Our Case Number: ACP-323980-25

Your Ref: **ACP-323980-25**
Our Ref: **SID-NAT-2025-038**
(Please quote in all related correspondence)

**Proposed Strategic Infrastructure Development (SID): Proposed Water Supply Project
for the Eastern and Midlands Region**

Drawing No. 32105801-700-06101

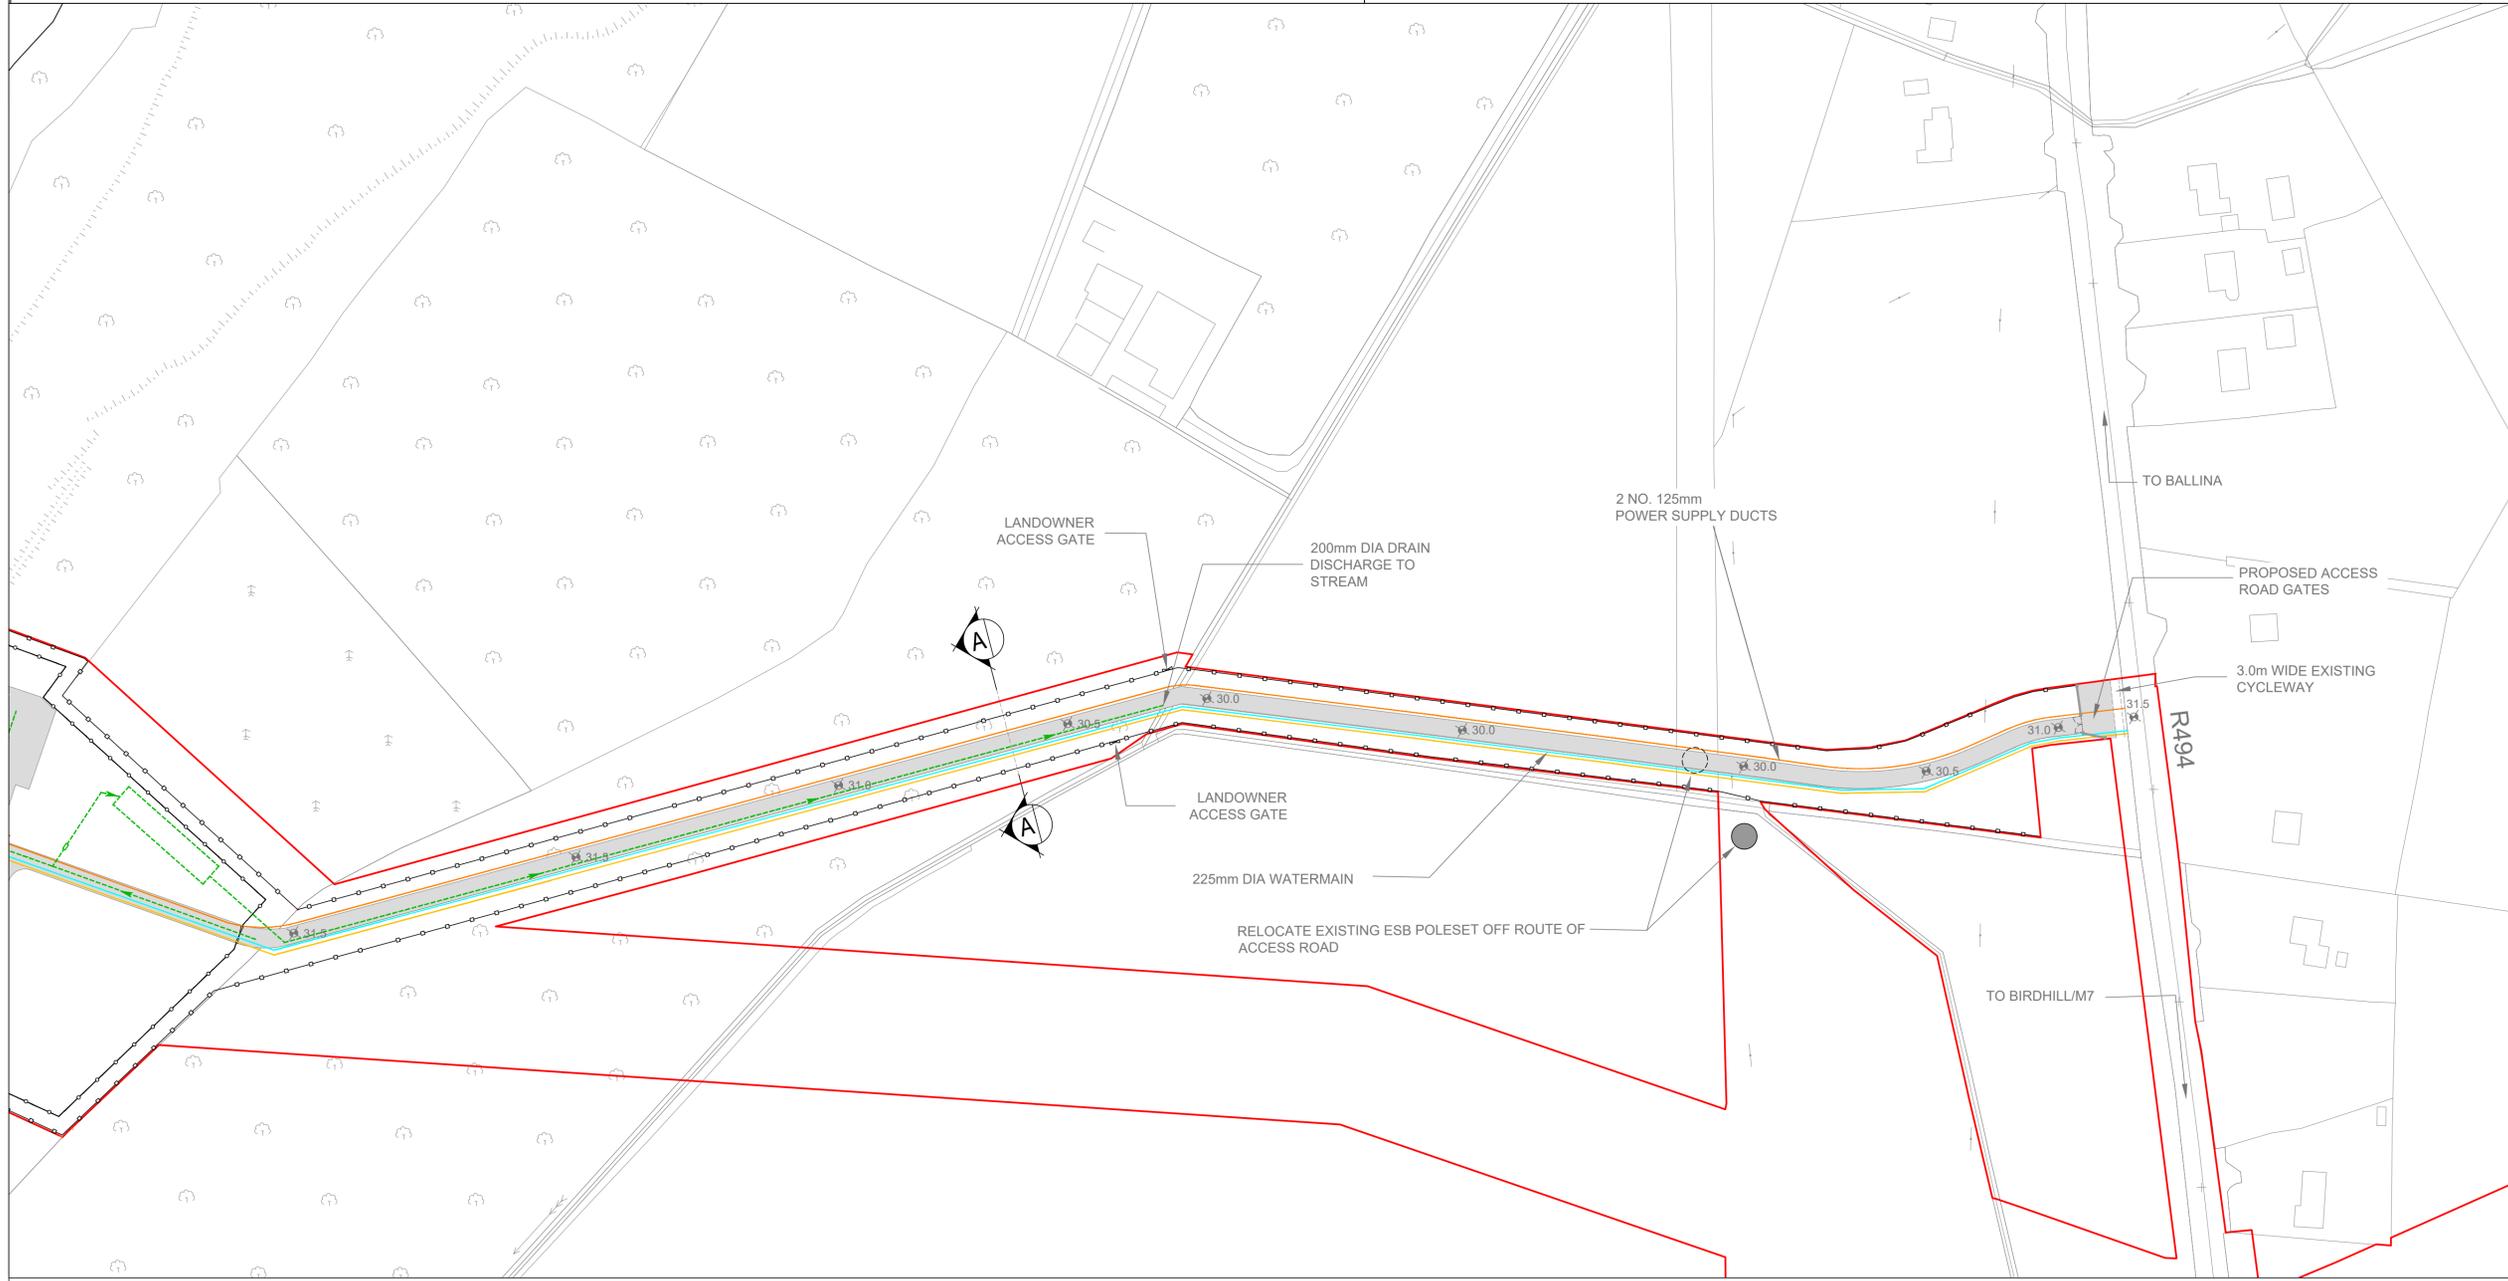
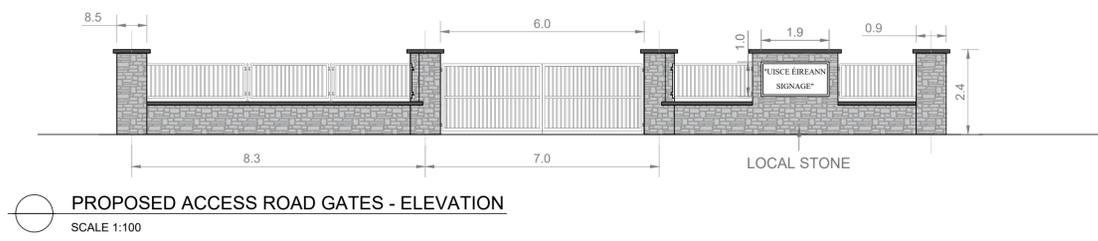
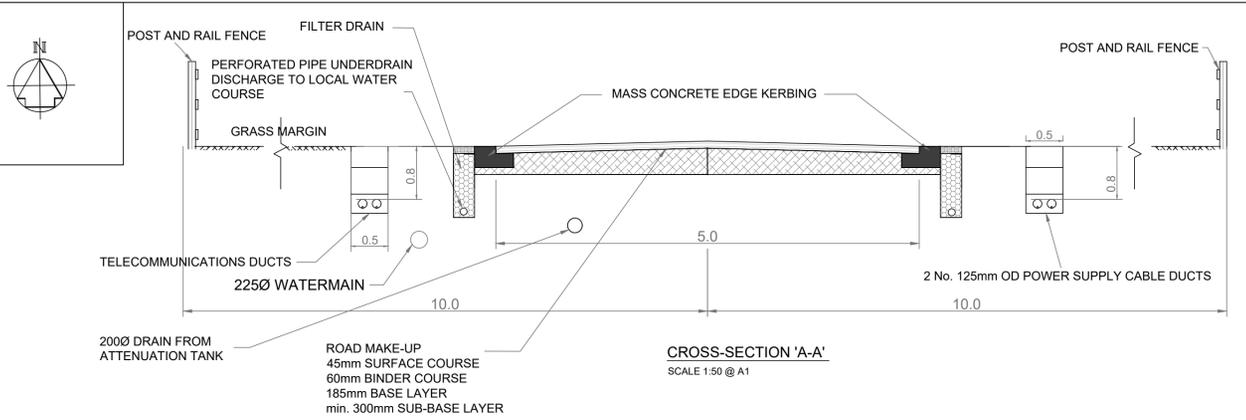
The Natura Impact Statement (NIS) states (p. 244, para. 905) that the abstraction will be “accurately verified and measured by flowmeter on the RWRM [Raw Water Rising Main].” That the maximum abstraction is not exceeded during severe droughts is clearly a requirement for the reliability of the predictions of no adverse effects on water levels upstream and downstream. However, the question of how precisely the flowmeter can be relied upon for verification needs further detail. Will it be sealed? Will prescribed authorities have access to inspect it? Will there be any concomitant drought monitoring of ecological parameters in the downstream Old River Shannon, or upstream north-east shore of Lough Derg (e.g. water flow, water temperature, wetland soil moisture deficit)?

Drawing file: Chapter 04 Proposed Project Description / Figure-4.64-Water-Treatment-Plant-Access-Road-Layout-Plan-and-Cross-Section.pdf

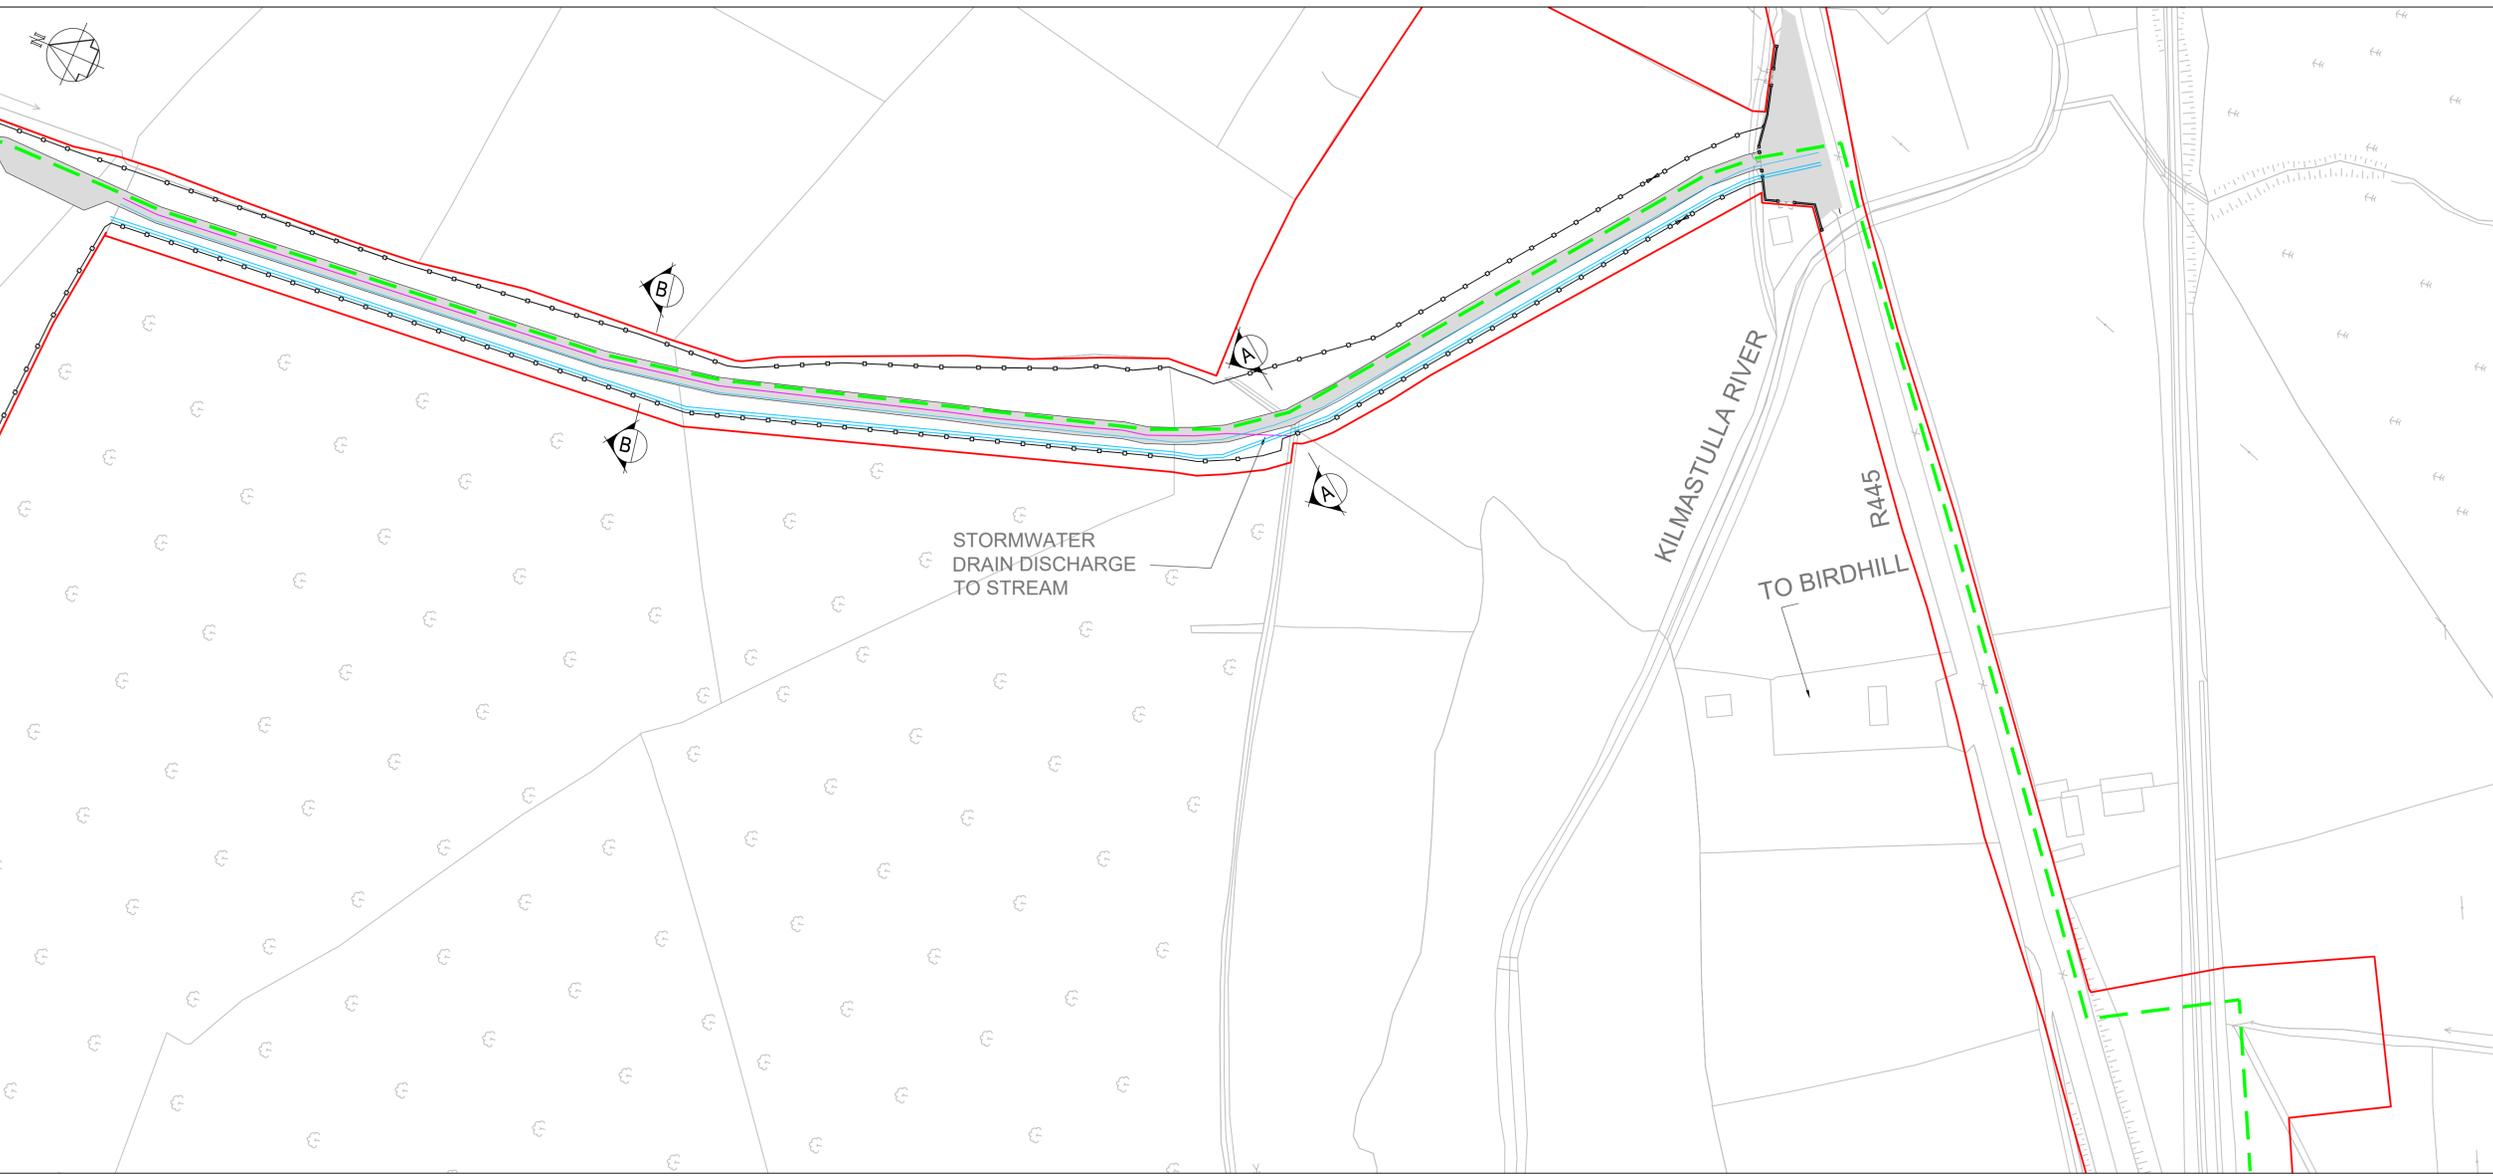
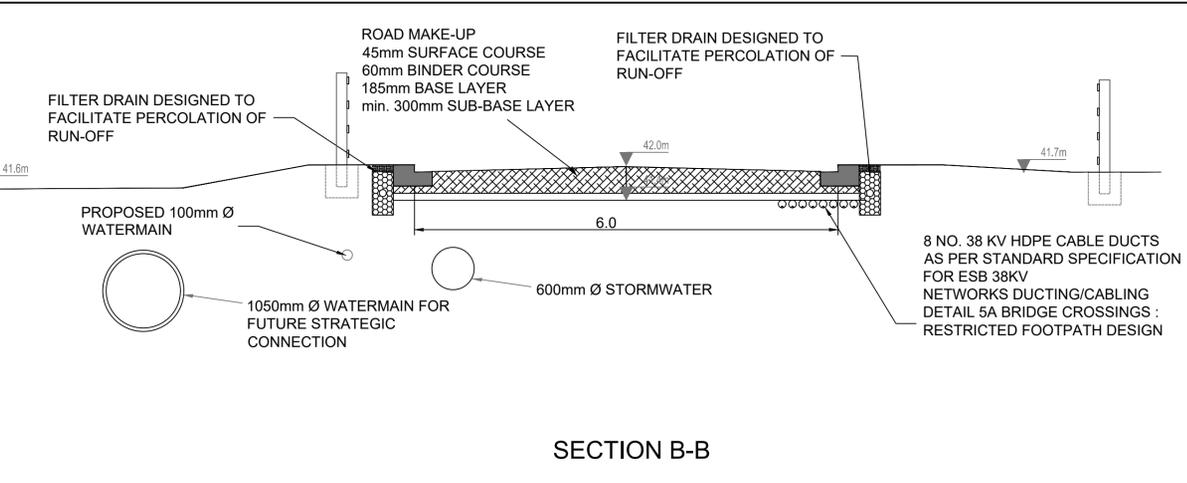
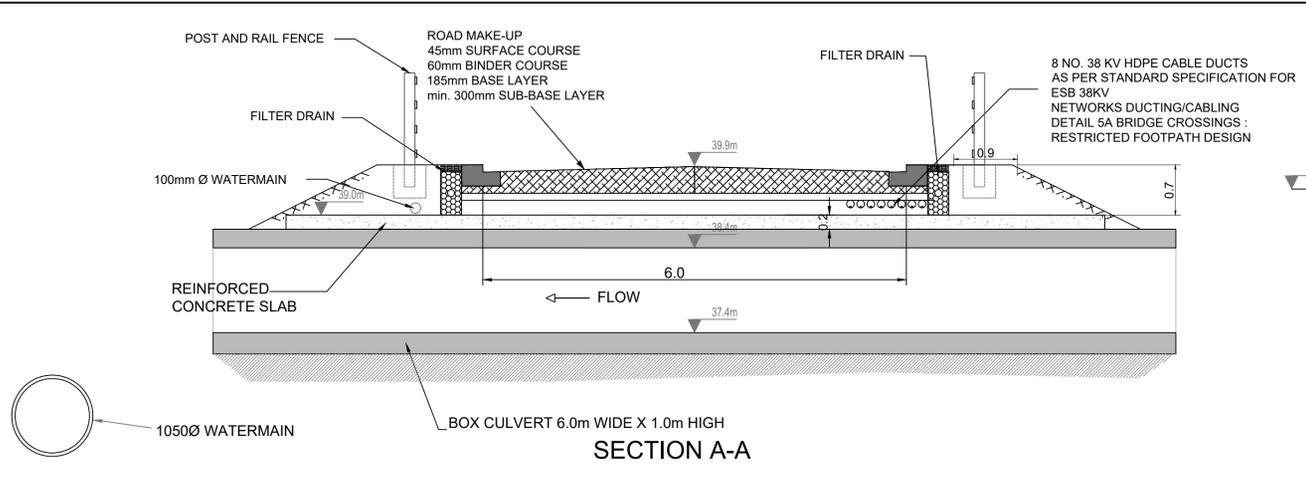
The cottage at Inchabeg proposed to be demolished (to allow for the construction of the Water Treatment Plant (WTP)) has been identified as a night roost for Lesser Horseshoes, as well as a day roost for Brown Long-eared and Natterer’s Bats. This was determined on

For these reasons, The Department recommends that the proposal is modified so that the dimensions of the replacement roost are increased to more closely match those of the building that it will be replacing, while retaining the current detailed design specifications (including for other bat species) which have been clearly described. The increased footprint should also allow for the inclusion of an insulated “cool room” as part of the lower level. The replacement roost should be viewed as an exceptional opportunity for long term investment in roosting resources to improve resilience and connectivity in the Lesser Horseshoe population at local and regional level.

However, due to the proximity of the proposed WTP, it is crucial that neither the replacement roost itself, or its connectivity with foraging areas, is compromised by lighting or noise from the WTP. In this regard, the detailed and specific planting mitigation that has been proposed is welcome. However, the use of solid screening along the southern boundary of the planted area is also recommended, particularly necessary while the planting is establishing, and on an ongoing basis to provide screening in winter from lighting from the WTP. The screening should be sufficiently robust and suitable to allow colonisation by Ivy, the establishment of which could be actively facilitated. Both Ivy, and Holly (of which a high proportion in the general planting mix is recommended) will provide shelter and local foraging cover in late autumn and winter when other foliage cover is absent. Early establishment of planting in locations where it does not impede the construction of the new roost would be useful.

The preservation of connectivity to the south, and particularly to the plantation immediately south of the proposed WTP, is an important consideration. This is likely to require additional planting in a north-south alignment along at least one side of the site to provide a sheltered commuting corridor, and again permanent solid screening, in conjunction with highly sensitive lighting design, may need to be installed, given the extreme light sensitivity of Lesser Horseshoes and the scale of the adjacent WTP. Likewise, mitigation may be needed along the southern edge of the site to avoid light penetration into the adjoining plantation.
